Our ref: AN/2025/136678/01-L01
Your ref: H02-0511-25
Date: 18 June 2025

**Proposed development of 9 dwellings
Land off Postland Road, Crowland**

Environment Agency position

S418 - 01 - Elevations 1:100 @A3

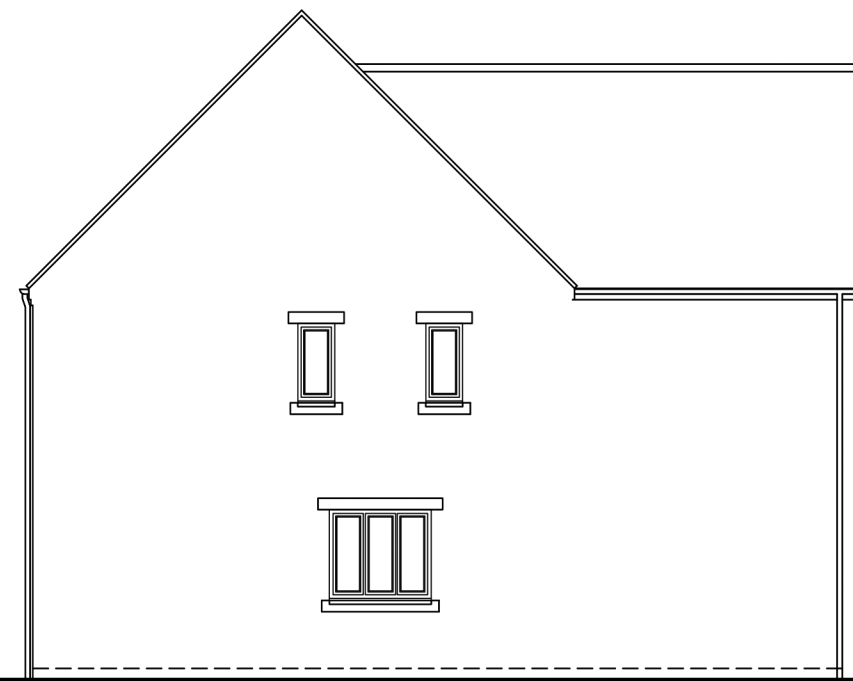
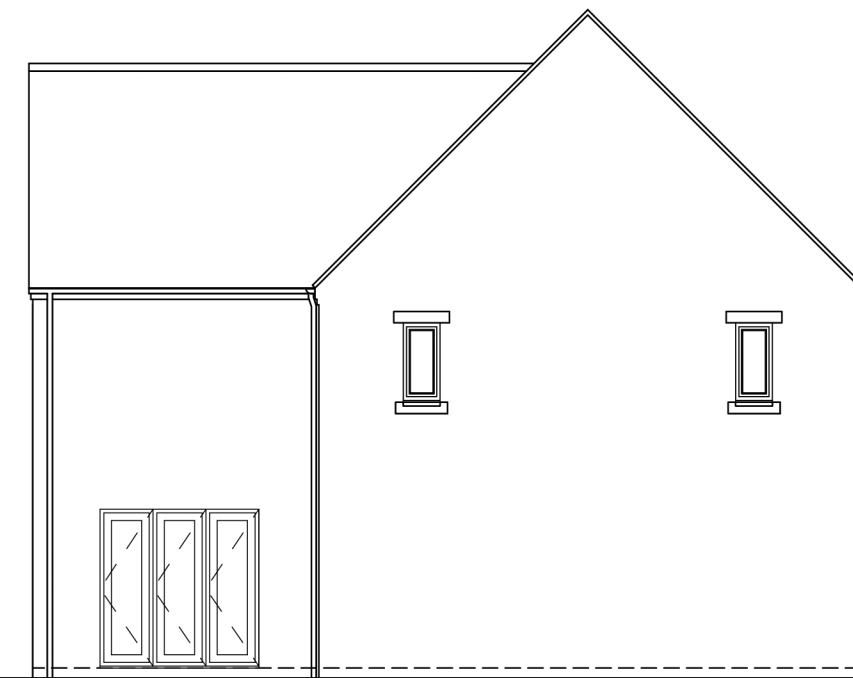
We note that the submitted FRA does not explain how the finished floor levels of the dwellings are intended to be achieved. The submitted elevation drawings do not suggest that the floor levels will be achieved through the building design, nor do they denote that the ground levels across the site will be raised.

We encourage your Local Planning Authority to be satisfied that the recommendations of the submitted FRA can be fully implemented, and that there are no wider planning implications on matters such as surface water flooding or design.

- The dwellings shall have a minimum of 2 storeys
- Finished floor levels shall be set 1.0m above the existing ground level, equivalent to 2.1m above Ordnance Datum (AOD)
- Flood resilient construction shall be incorporated to 2.9m AOD
- Demountable defenses shall be included to 0.6m above finished floor levels
